Application Ref:	3/2026/0354			 Ribble Valley Borough Council www.ribblevalley.gov.uk
Date Inspected:	26/06/26	Site Notice:	26/06/26	
Officer:	AR			
DELEGATED ITEM FILE REPORT:				
				APPROVAL

Development Description:	Proposed demolition of existing side extension and rear conservatory. Construction of new two-storey side extension and single-storey rear extension.
Site Address/Location:	13 Brookside Old Langho BB6 8AP

Client	Liam Wilson		
Project	13 Brookside, Old Langho 2 Storey Side Extension		
Drawing	Scheme 1 - plans & elevations		
Date	Drawn by	Scales	
April 2026	MJ	1:50	@ A1
Job No - Dwg No - Rev	HA26008 - SK1 - C

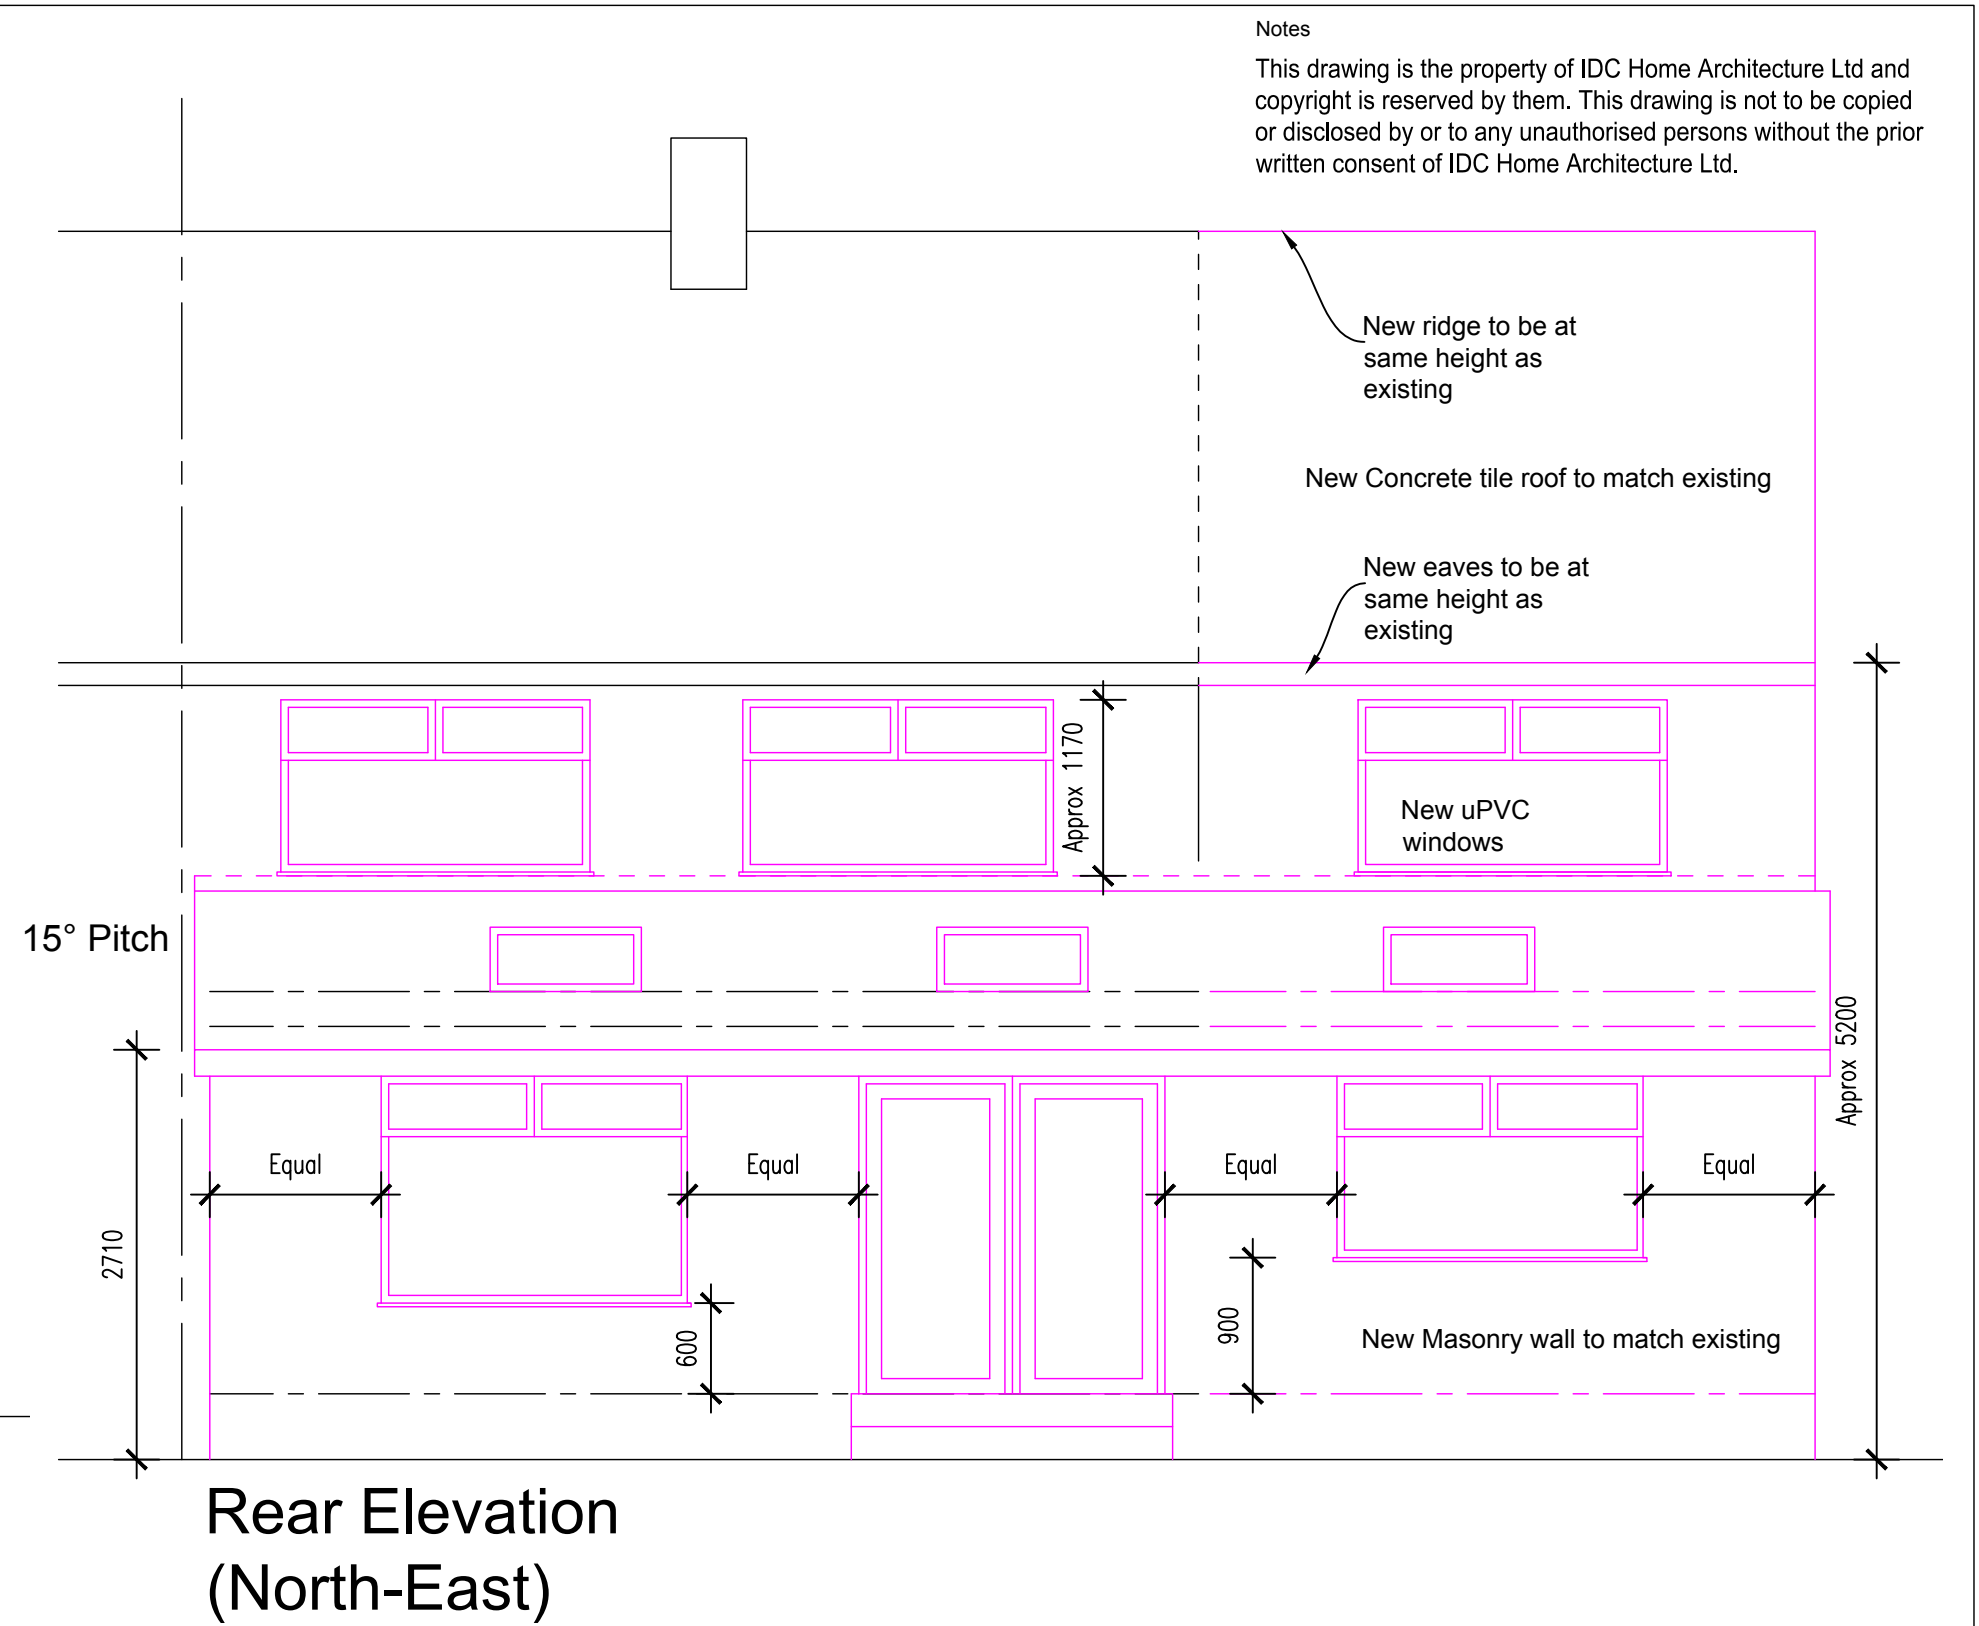
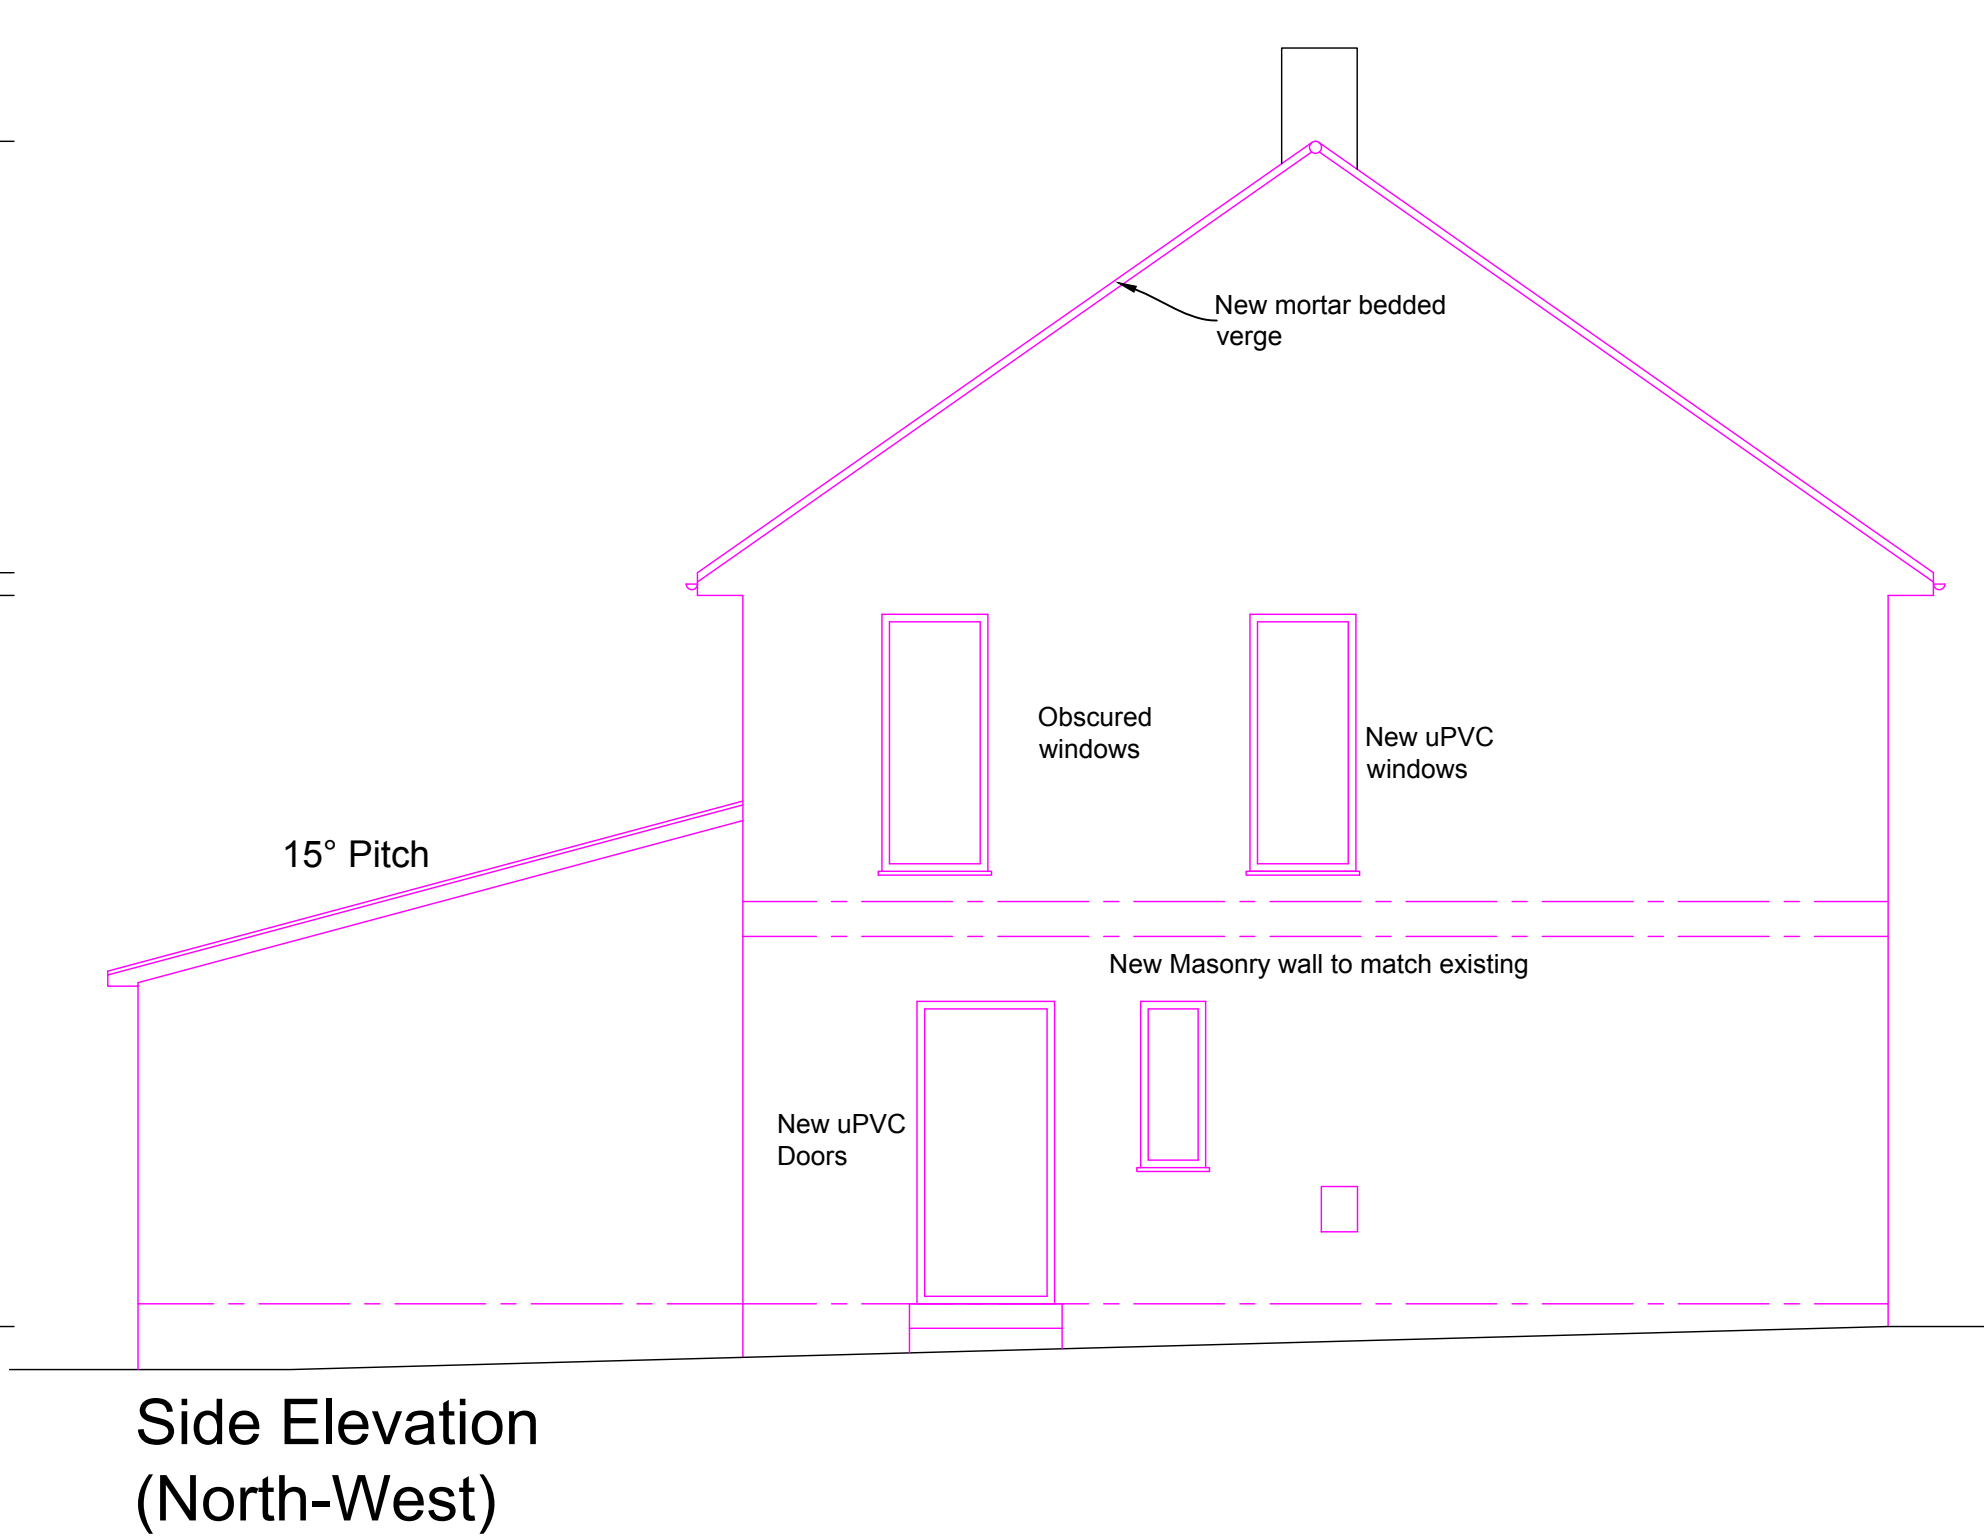
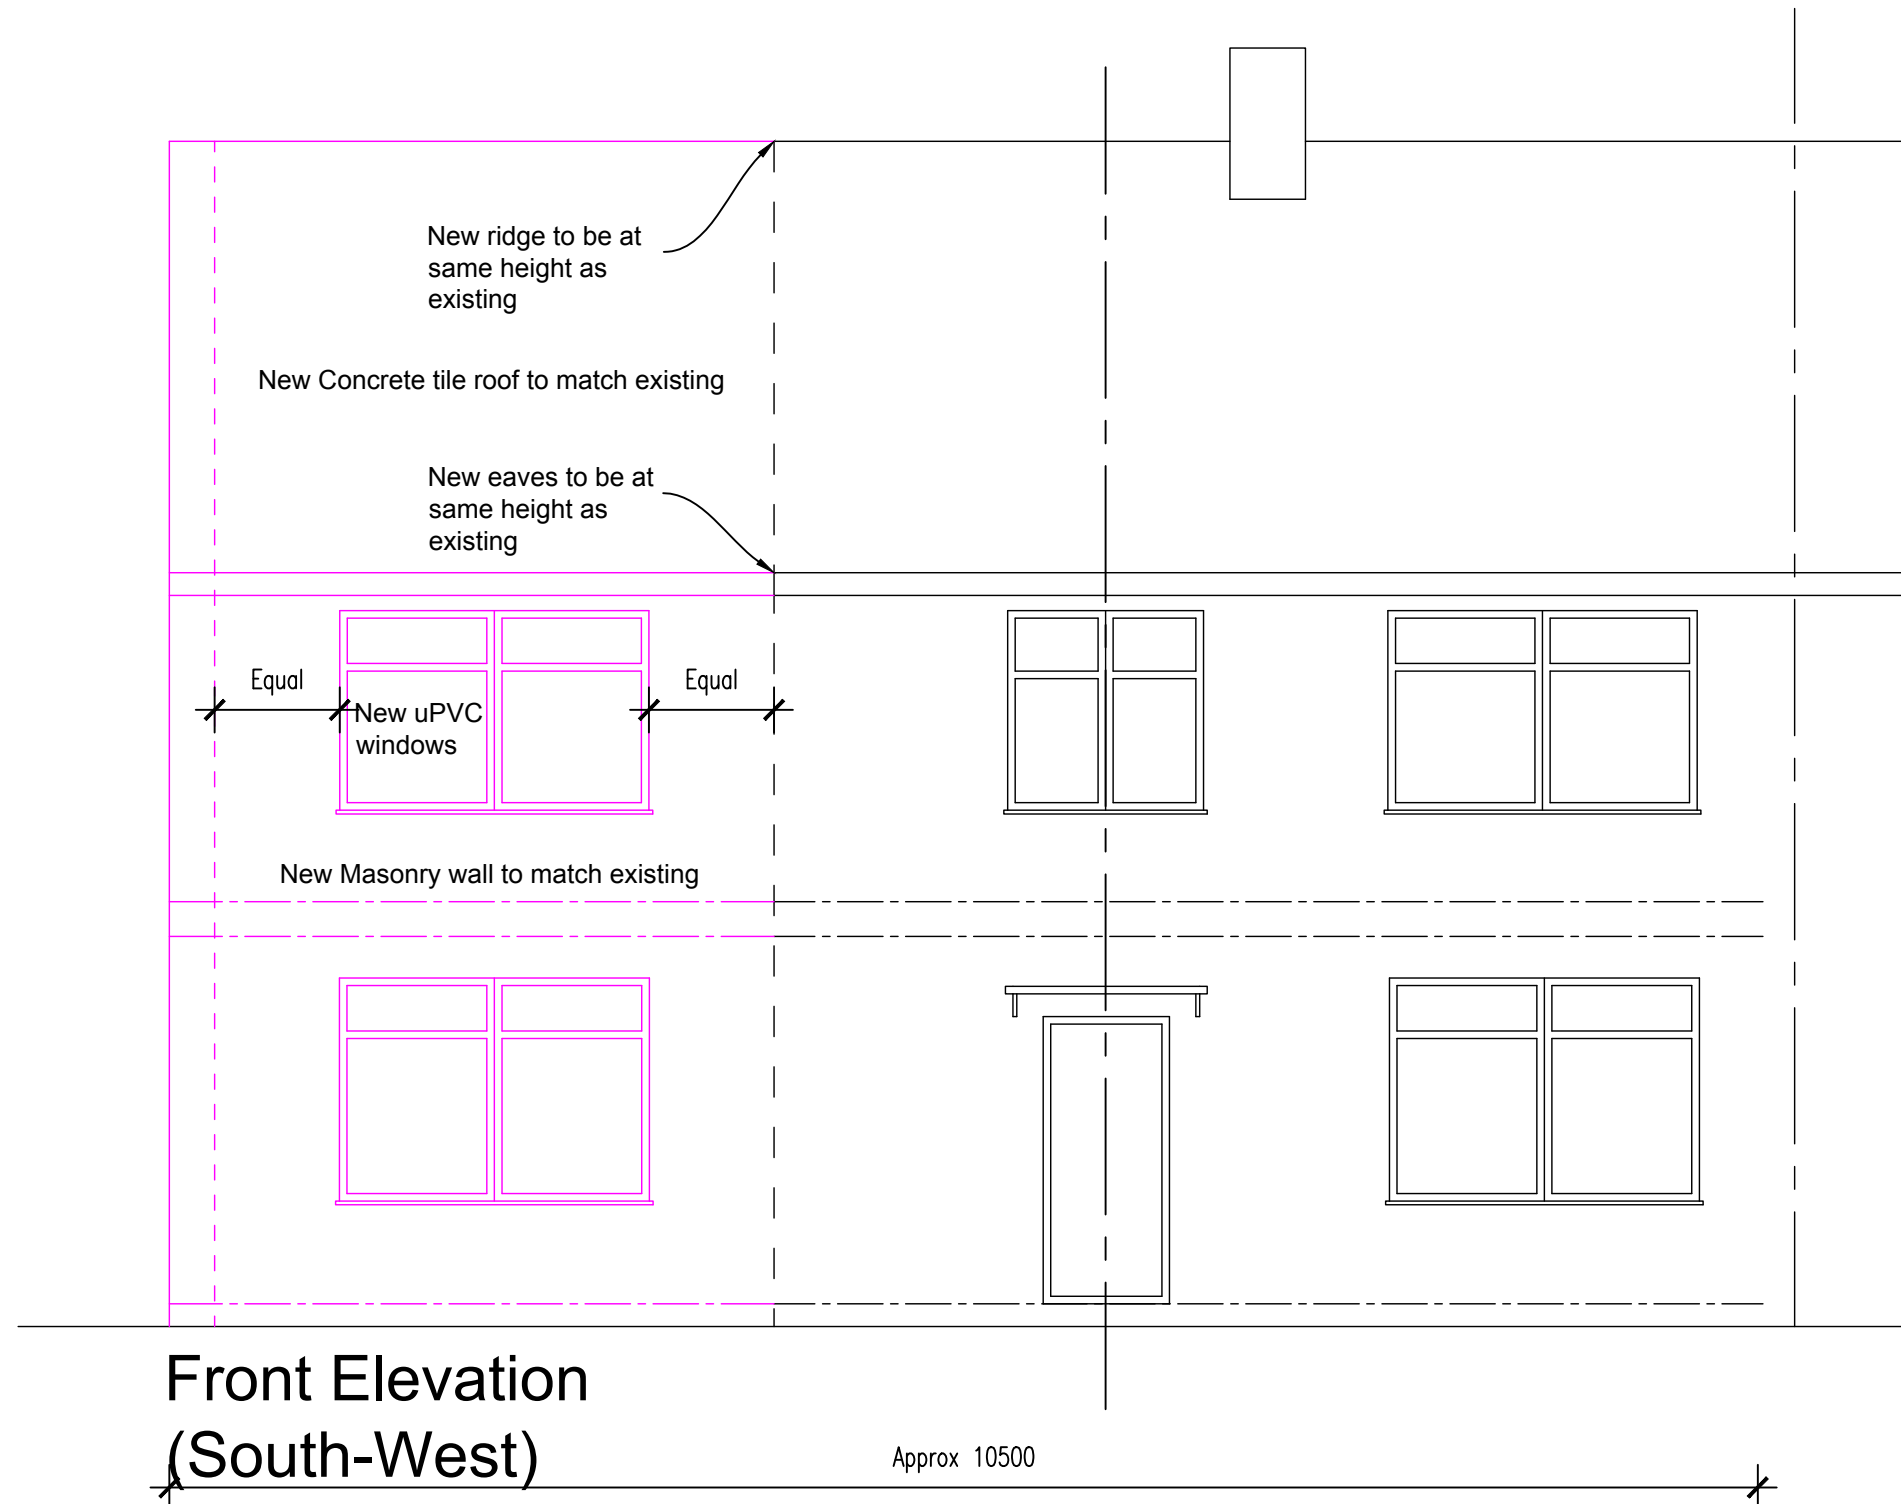
The proposed openings to the front and rear elevations of the two-storey extension would offer views comparable to those currently provided by the existing window arrangement of the main dwelling. The openings proposed to the north-western side elevation would face habitable room windows on the gable elevation of the adjacent property at No. 12 Brookside. However, these new proposed openings would be set approximately 9 metres from the first-floor windows on No. 12 Brookside’s side elevation. To mitigate any potential impacts on privacy, it is recommended that these windows be conditioned to be obscure glazed.

Ordinarily, the Local Planning Authority seeks to ensure that two-storey extensions are both set down from the main ridgeline and set back from the principal elevation. This approach is intended to ensure that extensions appear subservient to the main dwelling. In this case, such amendments were requested prior to determination; however, the applicant did not submit revised plans addressing the planning officer’s concerns regarding potential visual impact. As a result, the proposed extension would be flush with both the principal elevation and the main ridgeline of the dwelling.
